Development Review Checklist

Level I / **Level II** / Level III / Master Plan
 Project Name: Luminato
 Address: 169 Newbury Street
 Description: Alteration / Addition / **New Construction**
 Date Received: 03/28/16 Prelim / **Final**
 Planner: Caitlin Cameron

Complies	More Info	Does Not Comply	N/A	Comments
BUILDING DESIGN STANDARDS (BDS)					Review (3/14/16) Caitlin Cameron, Rick Knowland, Jean Fraser Comment: 3 rd Floor Plan missing

2 | EAST ELEVATION
 1/8" = 1'-0"
 0 2'-0" 4'-0" 8'-0" 16'-0"

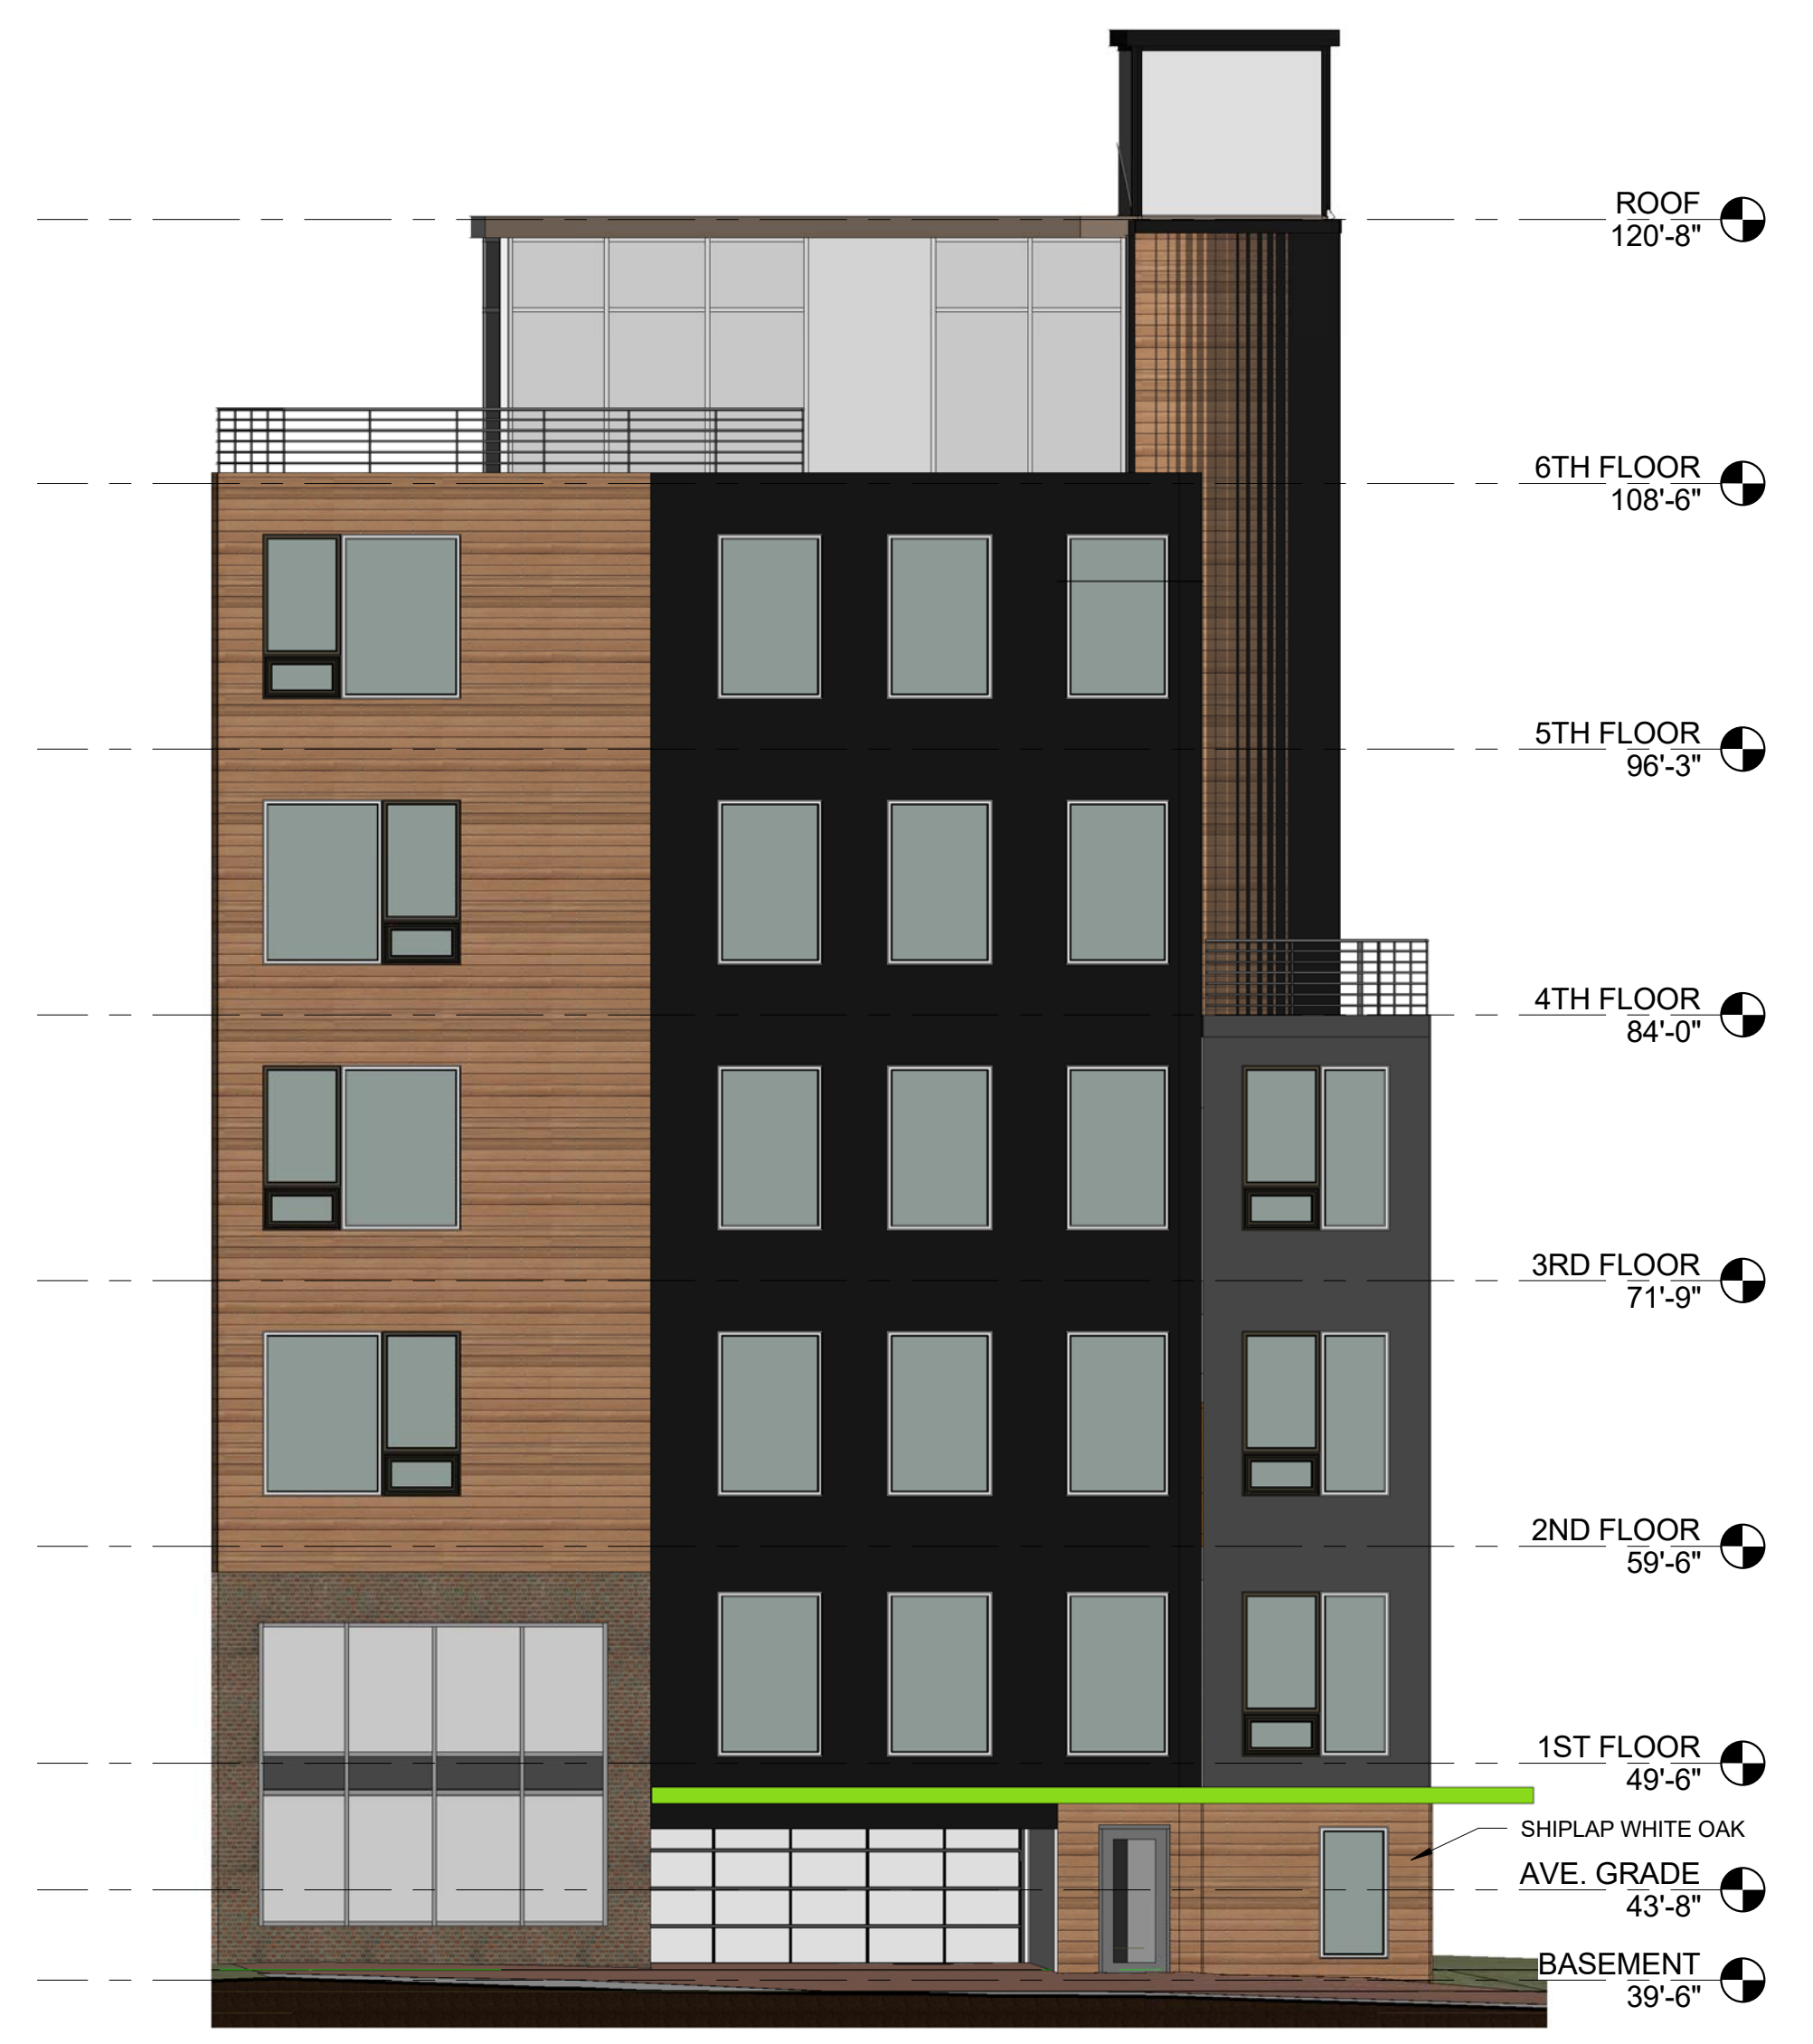
4. Fenestration					
Intent	<input checked="" type="checkbox"/>	<input checked="" type="checkbox"/>	<input type="checkbox"/>	<input type="checkbox"/>	East Elevation does not match floor plans.
Guidelines	<input checked="" type="checkbox"/>	<input type="checkbox"/>	<input type="checkbox"/>	<input type="checkbox"/>	
Standard 4.1 (UA only)	<input type="checkbox"/>	<input type="checkbox"/>	<input type="checkbox"/>	<input checked="" type="checkbox"/>	
Standard 4.2	<input checked="" type="checkbox"/>	<input type="checkbox"/>	<input type="checkbox"/>	<input type="checkbox"/>	
Standard 4.3	<input checked="" type="checkbox"/>	<input type="checkbox"/>	<input type="checkbox"/>	<input type="checkbox"/>	No tinting
Standard 4.4	<input checked="" type="checkbox"/>	<input type="checkbox"/>	<input type="checkbox"/>	<input type="checkbox"/>	No spandrel glass

Intent	<input checked="" type="checkbox"/>	<input type="checkbox"/>	<input checked="" type="checkbox"/>	<input type="checkbox"/>	The Franklin garage façade was revised to meet the intent, guidelines, and standards. Visual interest with
Guidelines	<input checked="" type="checkbox"/>	<input type="checkbox"/>	<input type="checkbox"/>	<input type="checkbox"/>	
Standard 3.1: 3 required	<input checked="" type="checkbox"/>	<input type="checkbox"/>	<input type="checkbox"/>	<input type="checkbox"/>	Projections – overhangs, stoop; Recessed entries; Expression lines at floors, trim; Changes in material type and texture
Standard 3.2	<input checked="" type="checkbox"/>	<input type="checkbox"/>	<input type="checkbox"/>	<input type="checkbox"/>	
Standard 3.3: Blank Wall	<input checked="" type="checkbox"/>	<input type="checkbox"/>	<input type="checkbox"/>	<input type="checkbox"/>

8. Structured Parking					
Intent	<input checked="" type="checkbox"/>	<input type="checkbox"/>	<input type="checkbox"/>	<input type="checkbox"/>	
Guidelines	<input checked="" type="checkbox"/>	<input type="checkbox"/>	<input type="checkbox"/>	<input type="checkbox"/>	The design of the Franklin garage façade was revised to include include details and materials found elsewhere in the architecture.
Standard 8.1	<input checked="" type="checkbox"/>	<input type="checkbox"/>	<input type="checkbox"/>	<input type="checkbox"/>	Articulation and visual interest was added to the Franklin garage façade. Elements include: plane changes carried all the way down the façade; upper floor cladding material carried further down the façade; windows incorporated into the upper parking deck; window details added; incorporated landscaping.
Standard 8.2	<input checked="" type="checkbox"/>	<input type="checkbox"/>	<input type="checkbox"/>	<input type="checkbox"/>
